Re: **San Mateo Manor at 612 San Mateo Blvd SE**
Erosion and Sediment Control Plan
Engineer's Stamp Date: 11/4/25 – L18E088 - (SWQ-2025-00066)

Based on the information in your submittal received on 12/11/25, the ESC Plan can't be approved until the following comments are addressed.

ESC-2

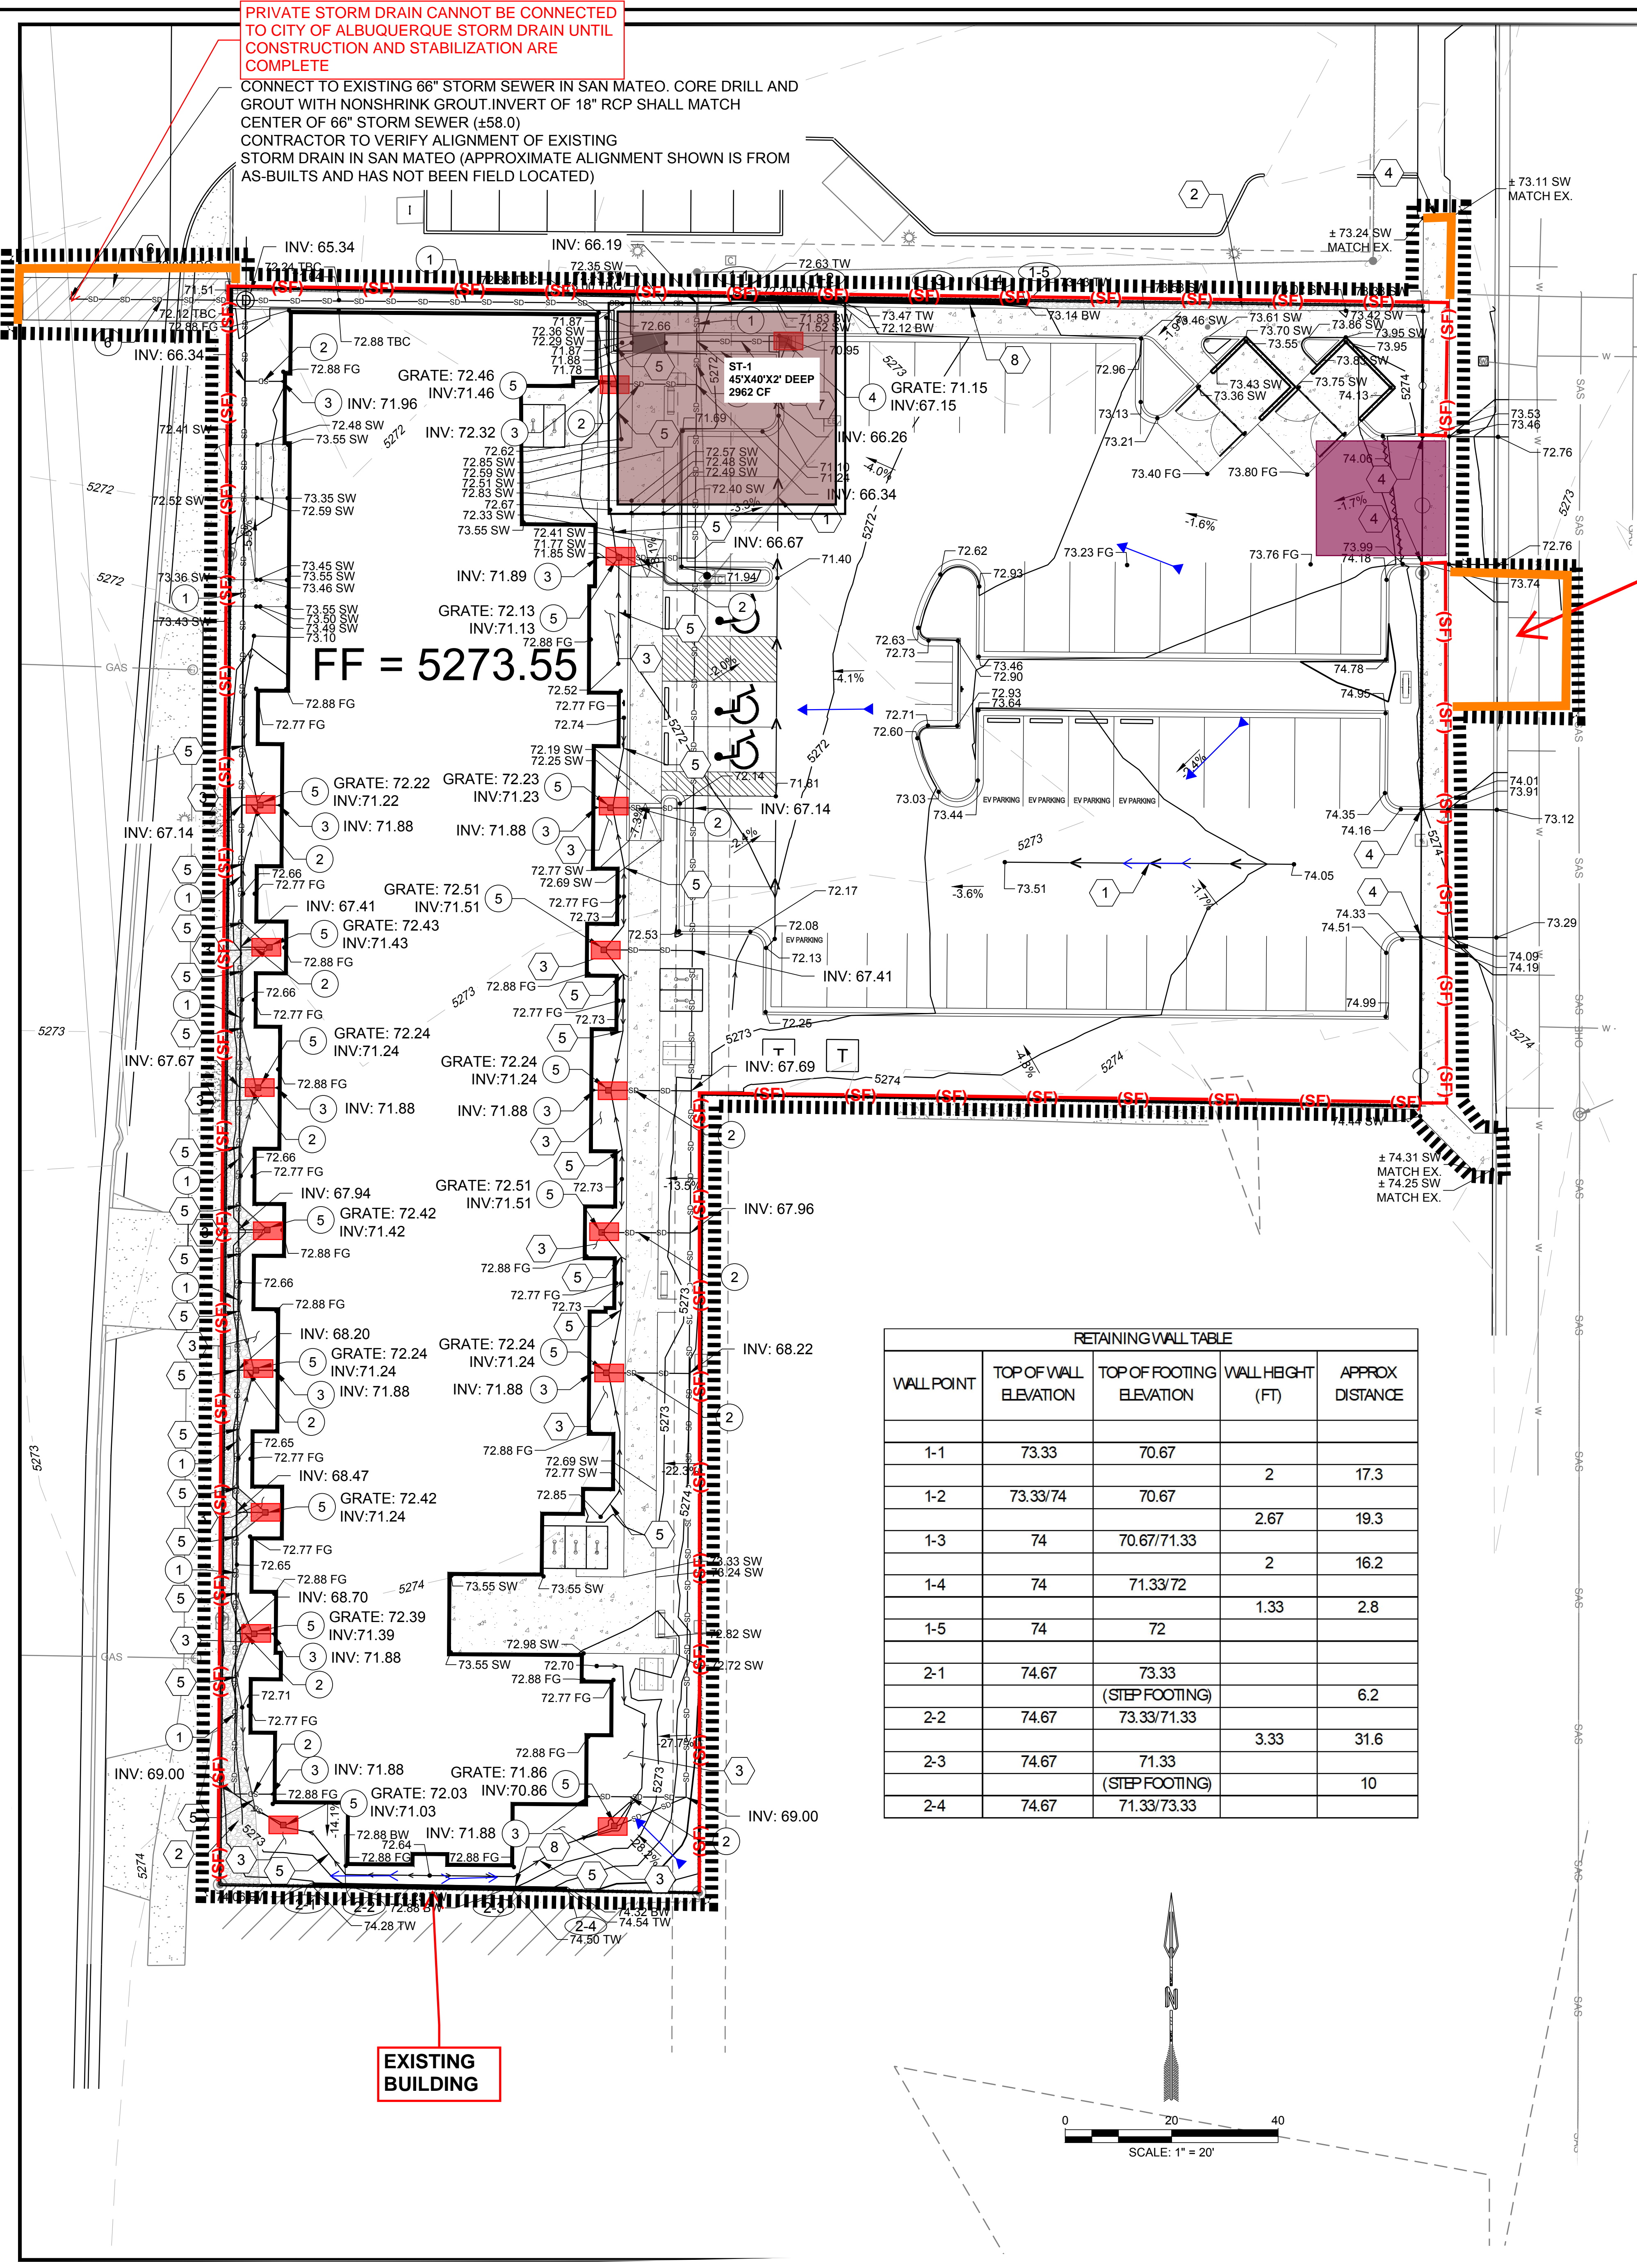
3. Add a separate sheet showing demolition areas, including the existing building, sidewalks, driveways, and other structures per CGP 7.2.4.b.i. Add a note to *“Provide waste containers (e.g., dumpster, trash receptacle) of sufficient size and number to contain construction and domestic wastes per CGP 2.3.3.e, including demolition debris.*

LANDSCAPE PLAN
San Mateo Manor Apartments
612 San Mateo Blvd. SE
Albuquerque, NM 87108
sheet no: **LS 101**

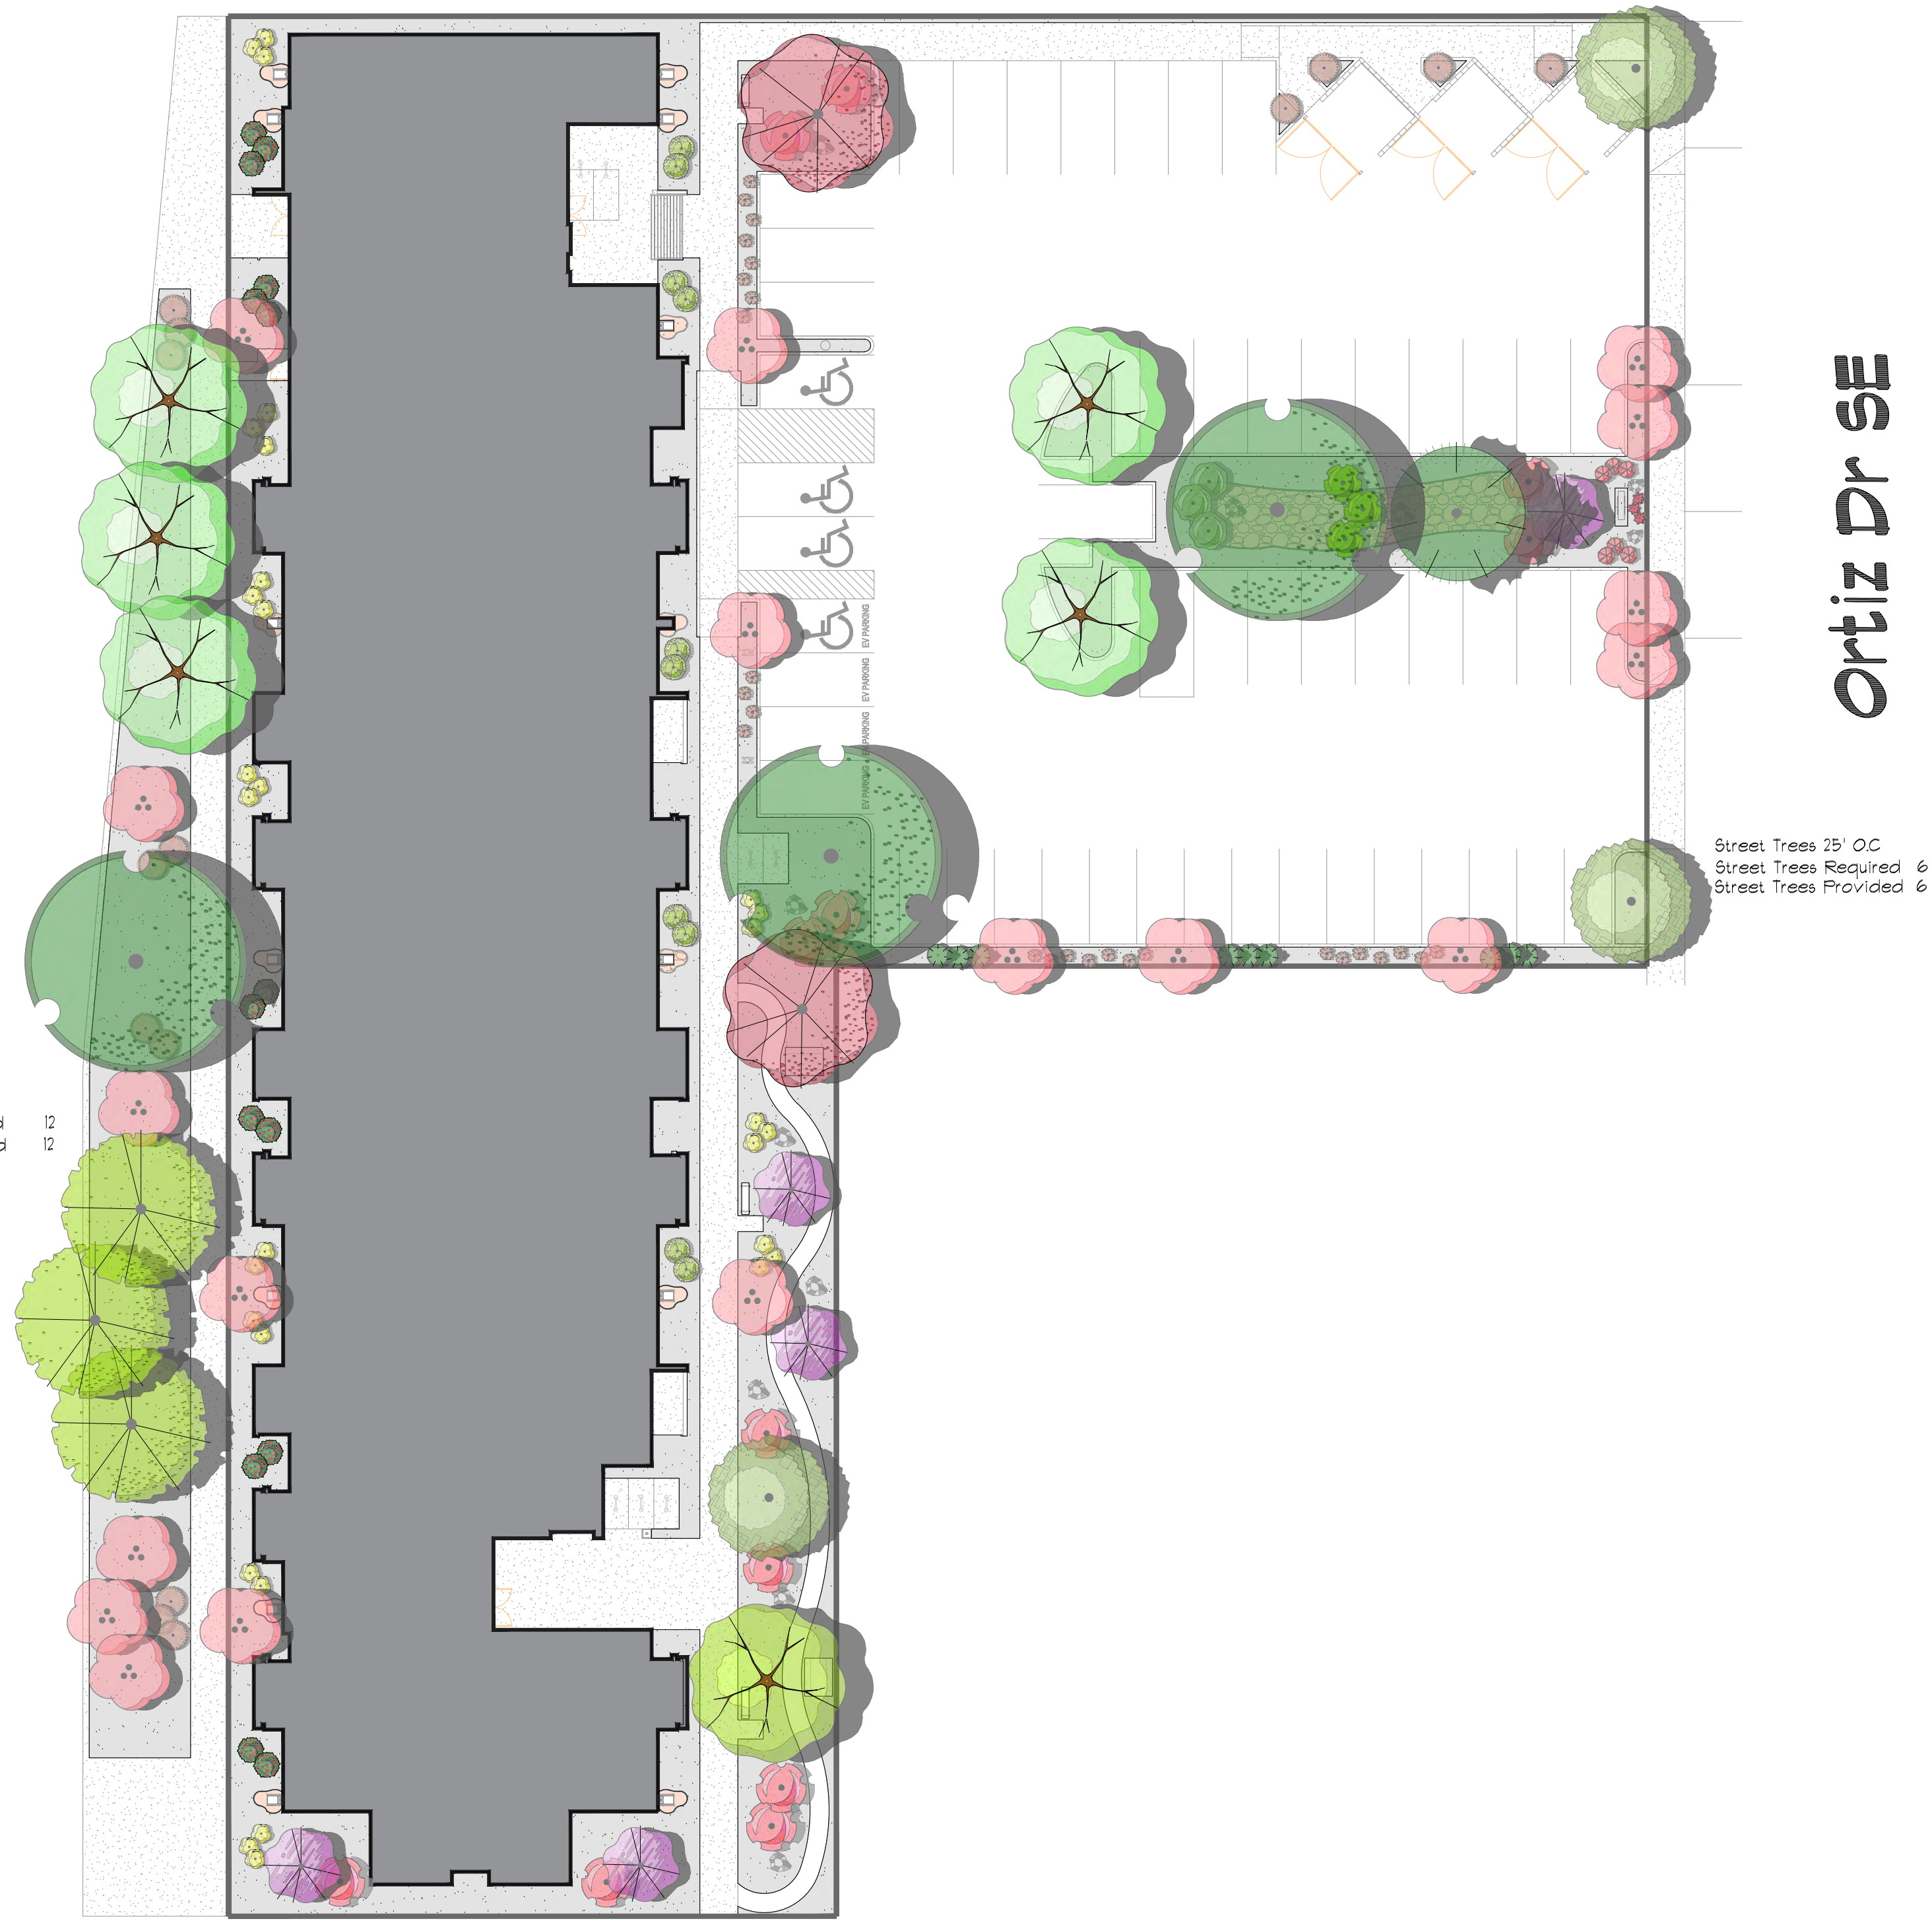
4. The SWPPP must include site-specific interim and permanent stabilization per CGP 9.6.1.c.i. The Landscape Plan can be used to satisfy this requirement and should be submitted separate from the ESC Plan with the application to the Stormwater Quality Section of the Planning Department, and it should be included in the SWPPP. Provide a specification on the ESC Plan for any disturbed areas not covered by the Landscape Plan.
